Application by Highways England for an Order Granting Development Consent for the M25 Junction 10 / A3 Wisley Interchange Improvements Project

Monte Blackburn and EG Group Land Holding/Drive Thru Starbucks Operational Site, Former San Domenico Site, A3 Cobham Objection to Development Consent Order - Application Ref: TR010030

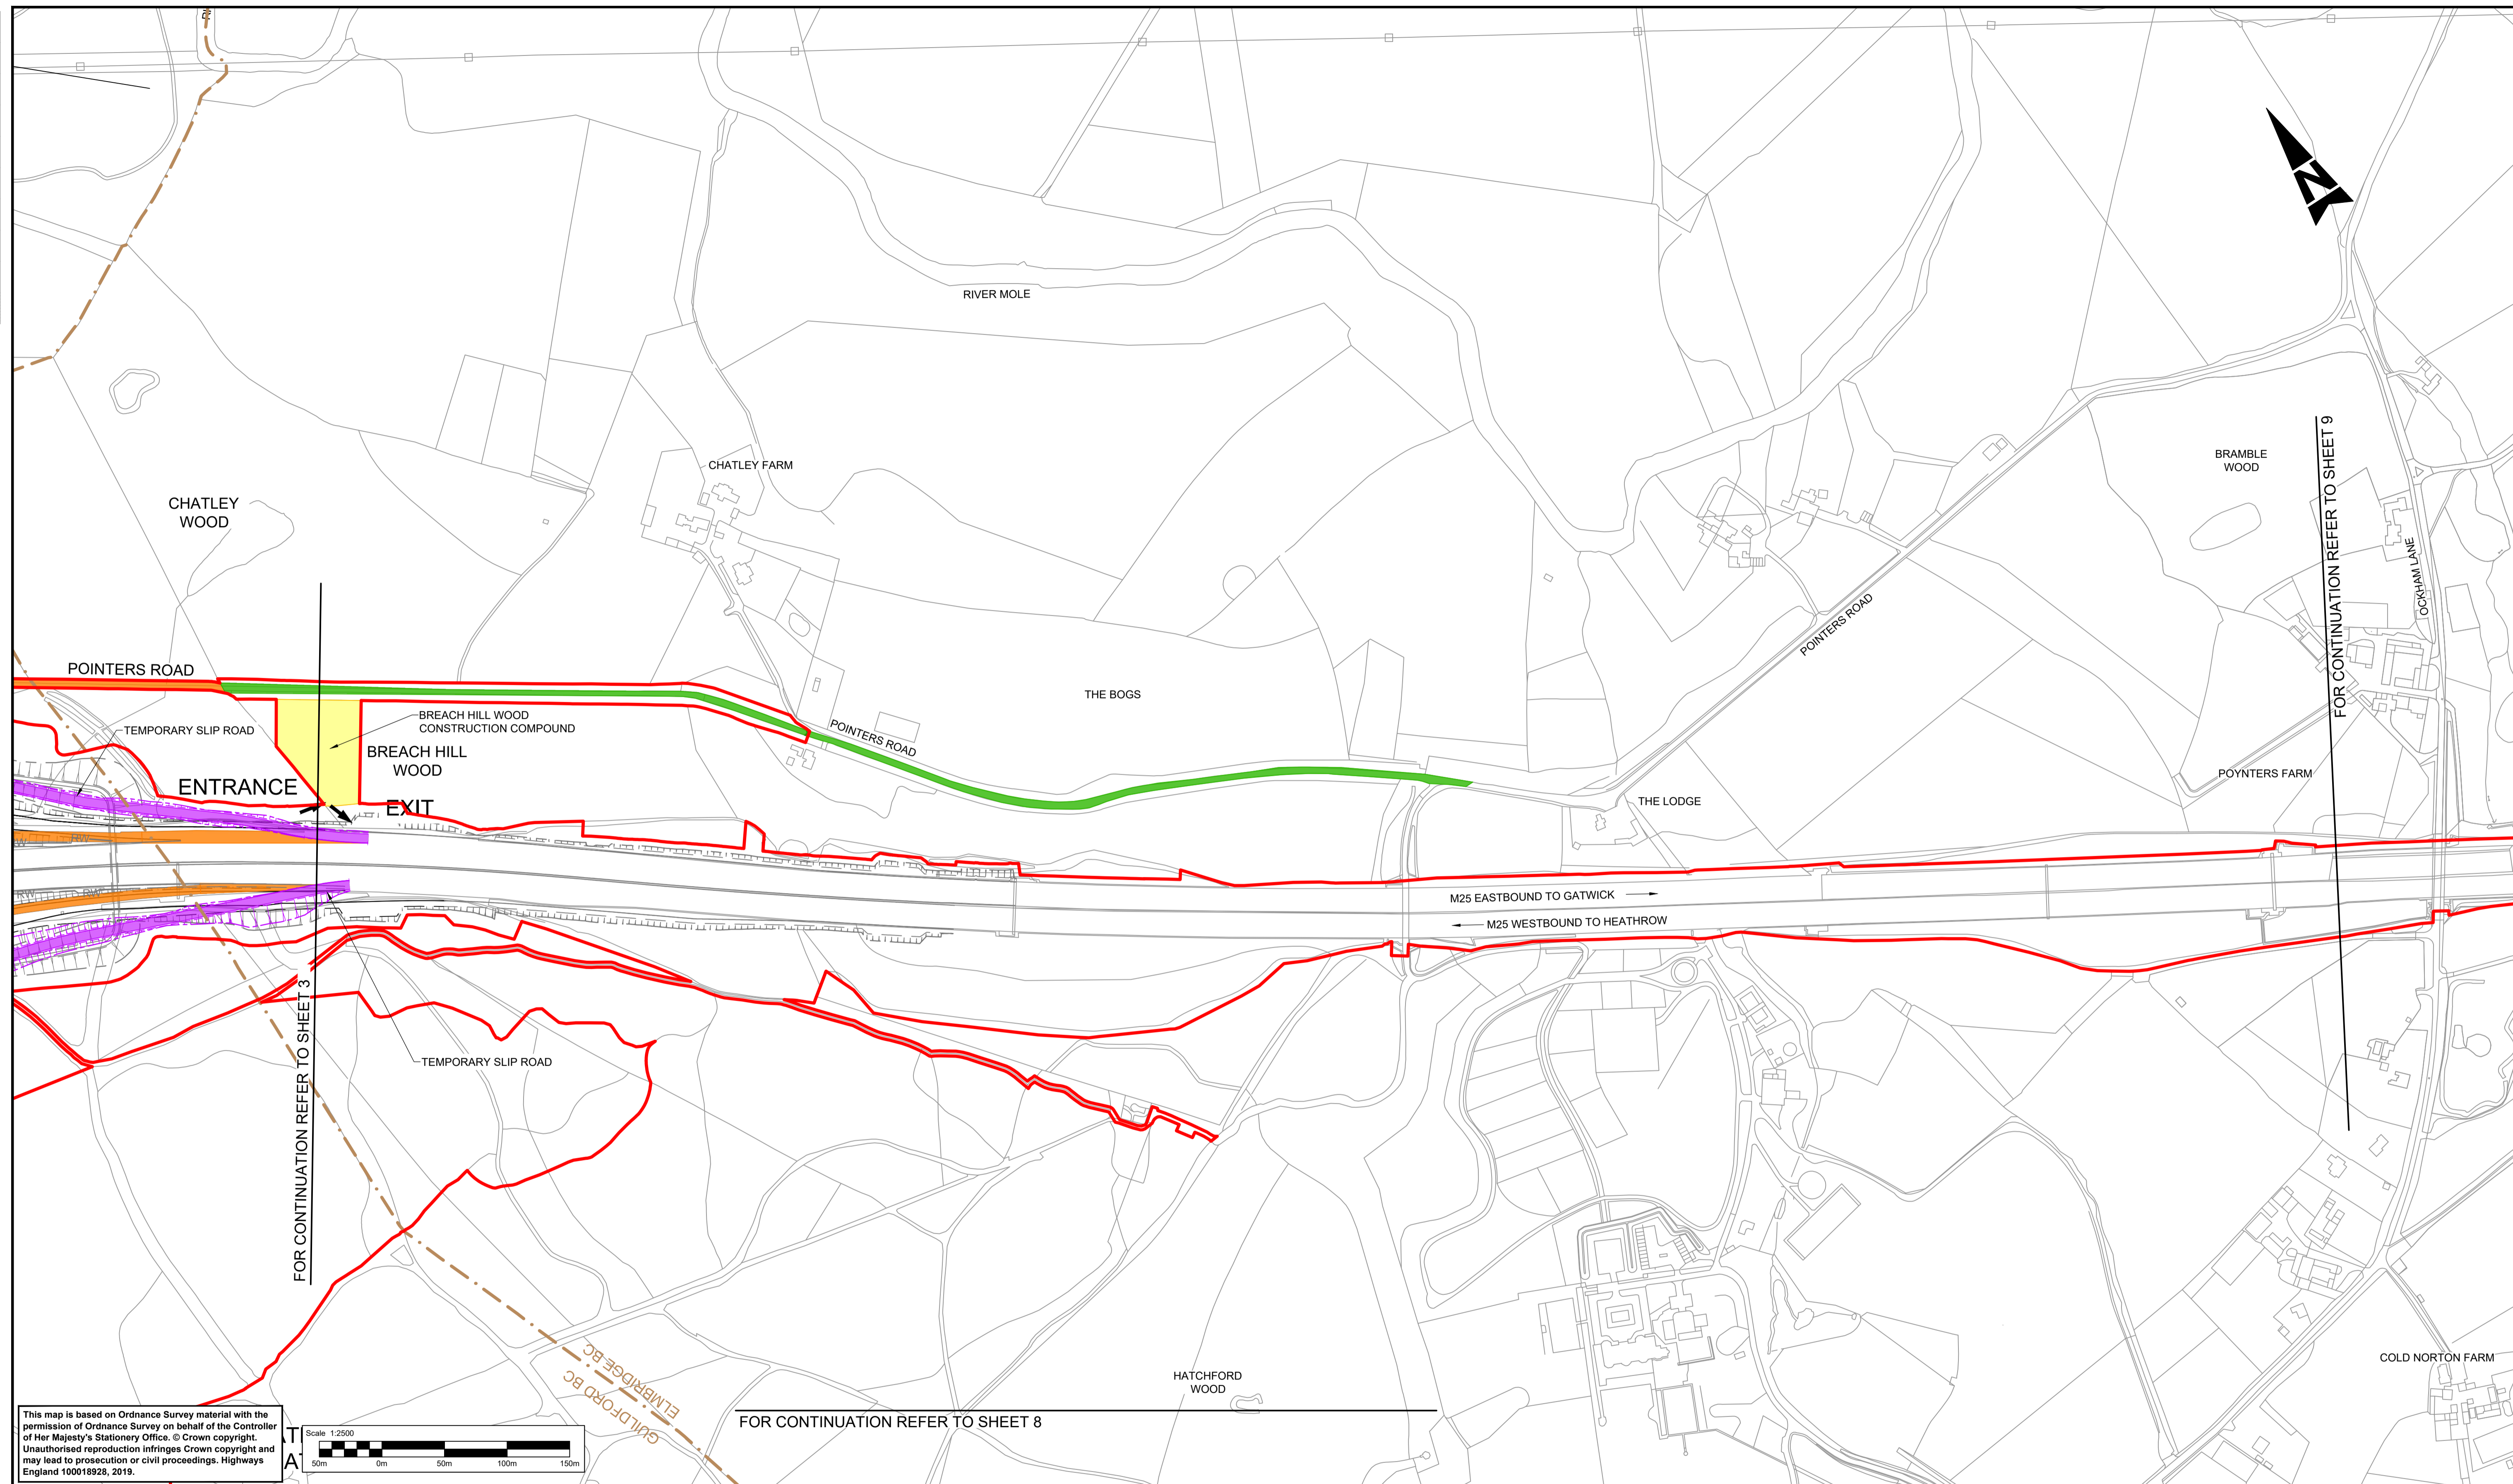
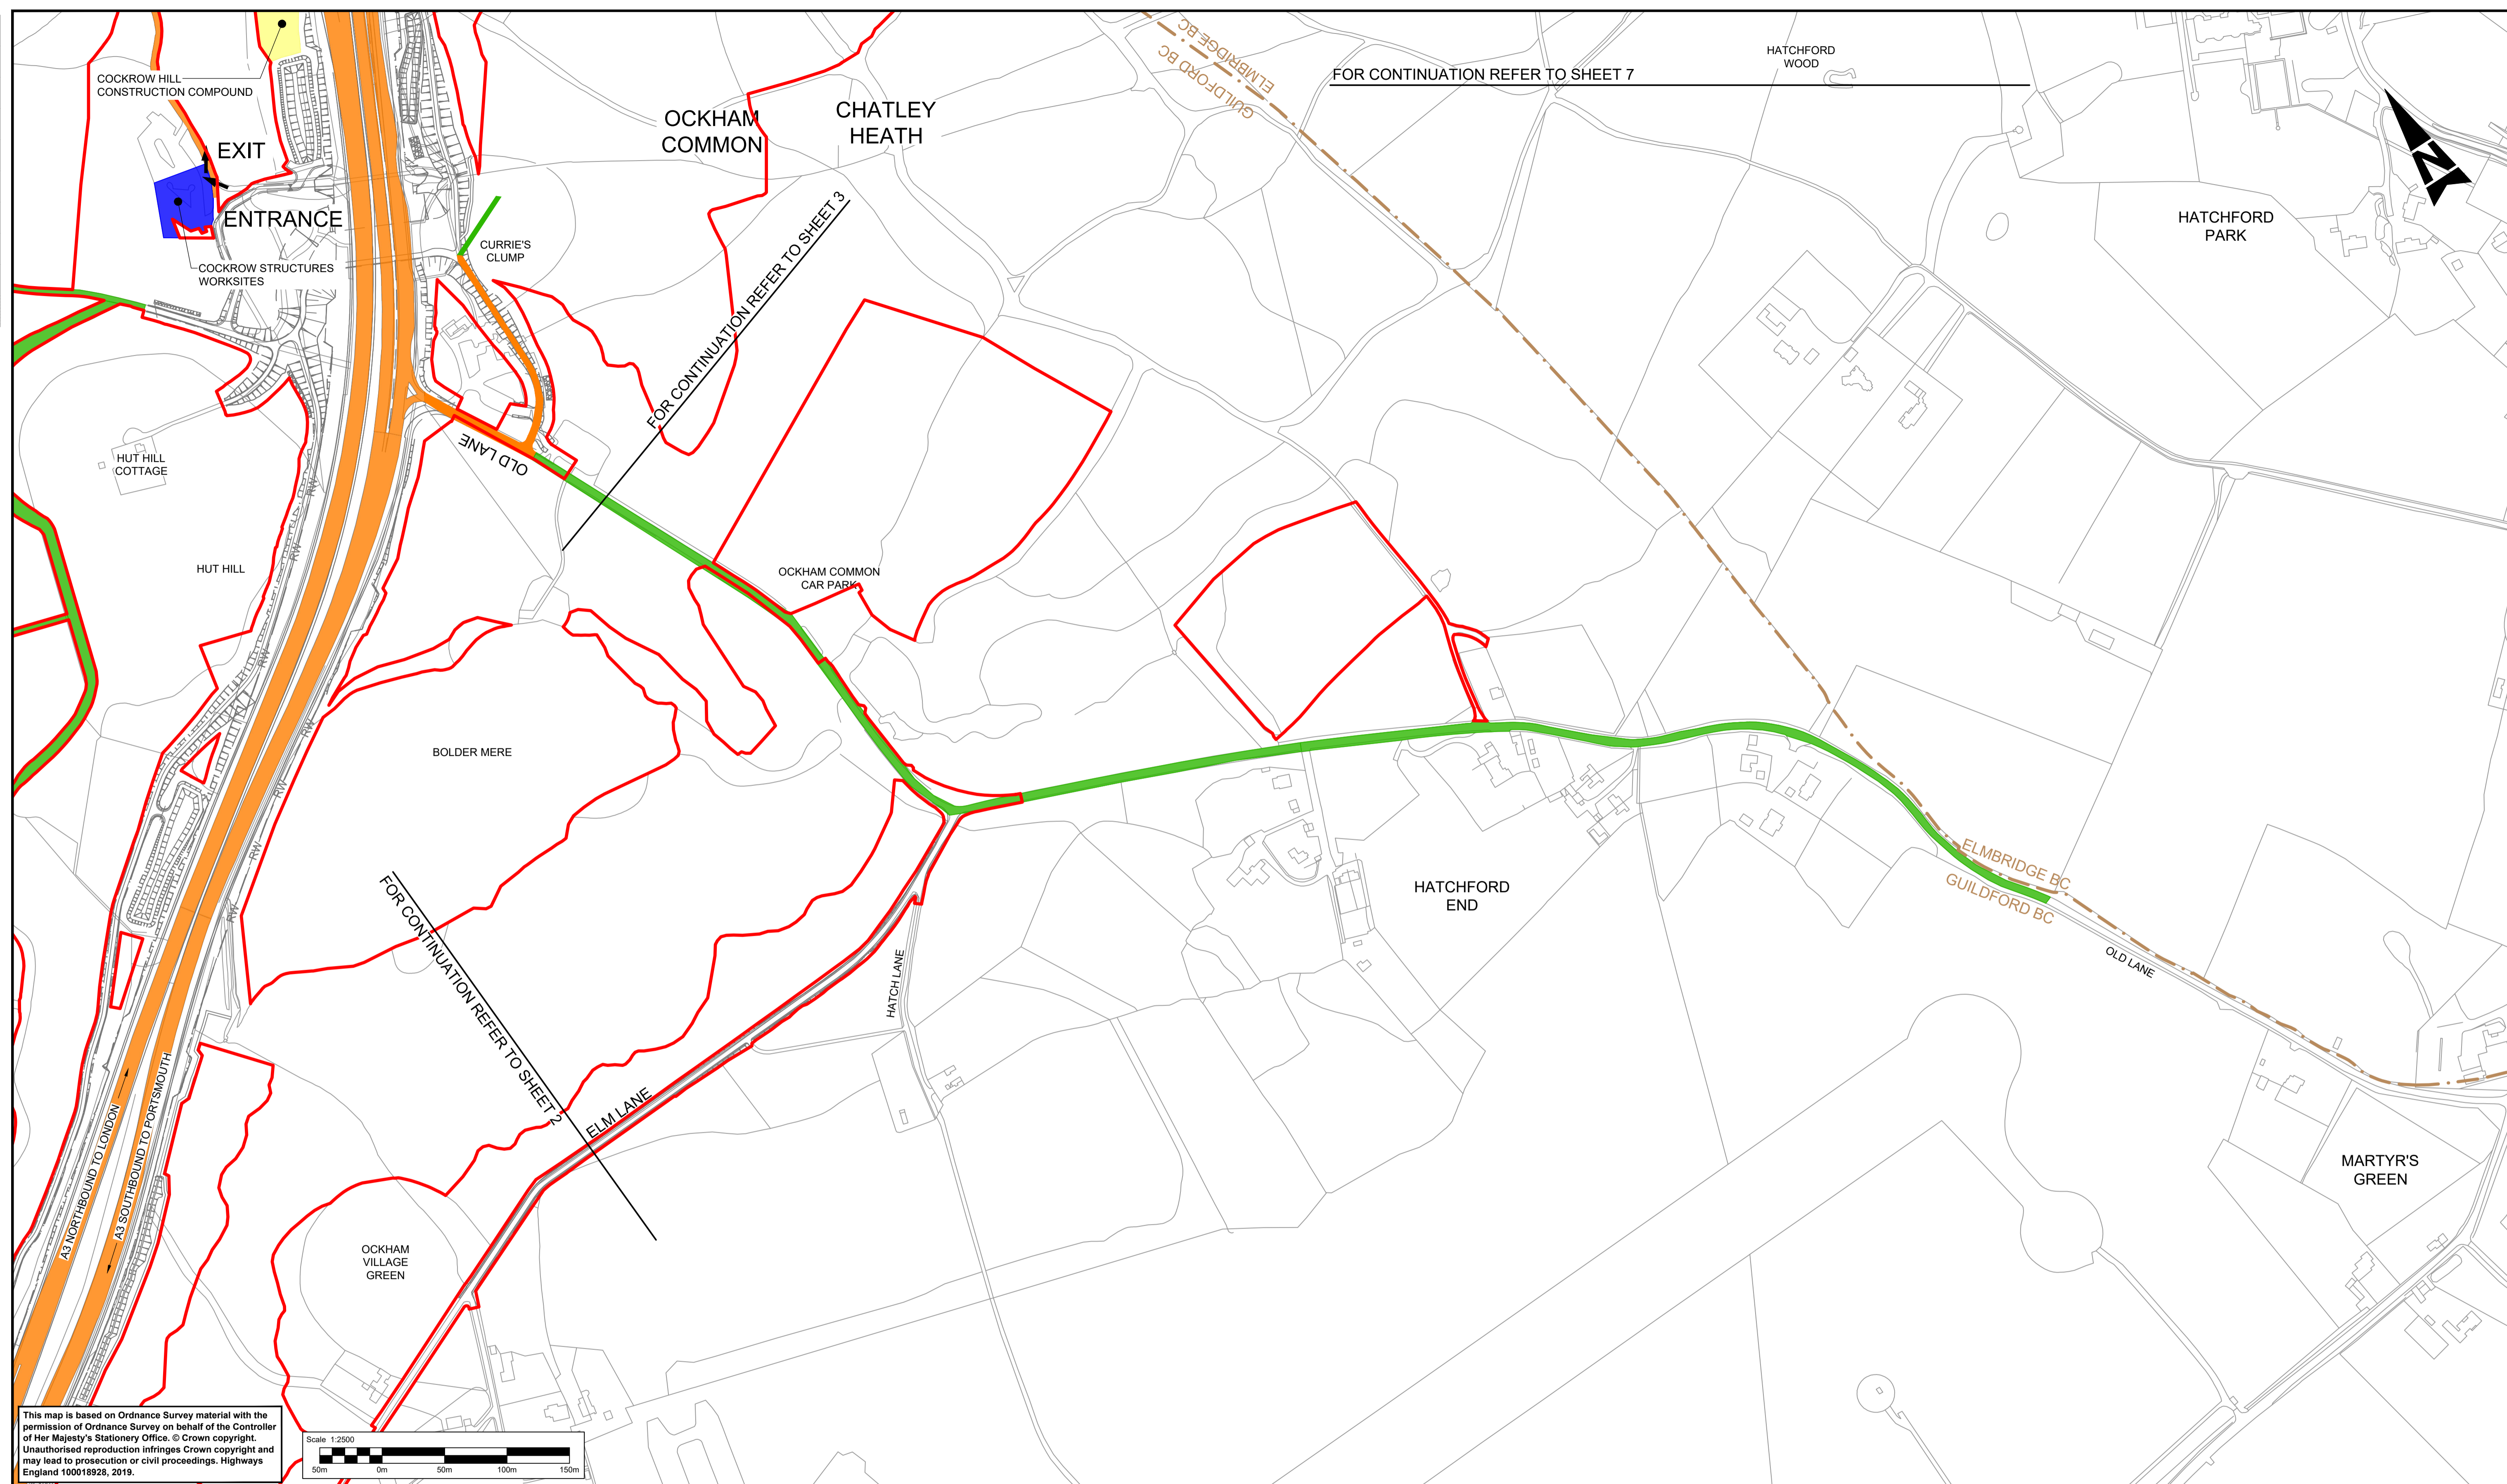
Highways England, as part of the construction phase works of the project, are proposing to acquire the site in its entirety in order to use our clients land as a construction compound, as shown below at **Figure 2** (Temp. Works Plan 4).

On this basis, even before day one of construction works, Highways England will be obligated to acquire the entire site from our clients in order to make use of the site as a construction compound as they have proposed. The suggestion that HE can return part of the site after construction with direct access from the A3 removed is absurd because the site will have no commercially beneficial use following the stopping up of the access.
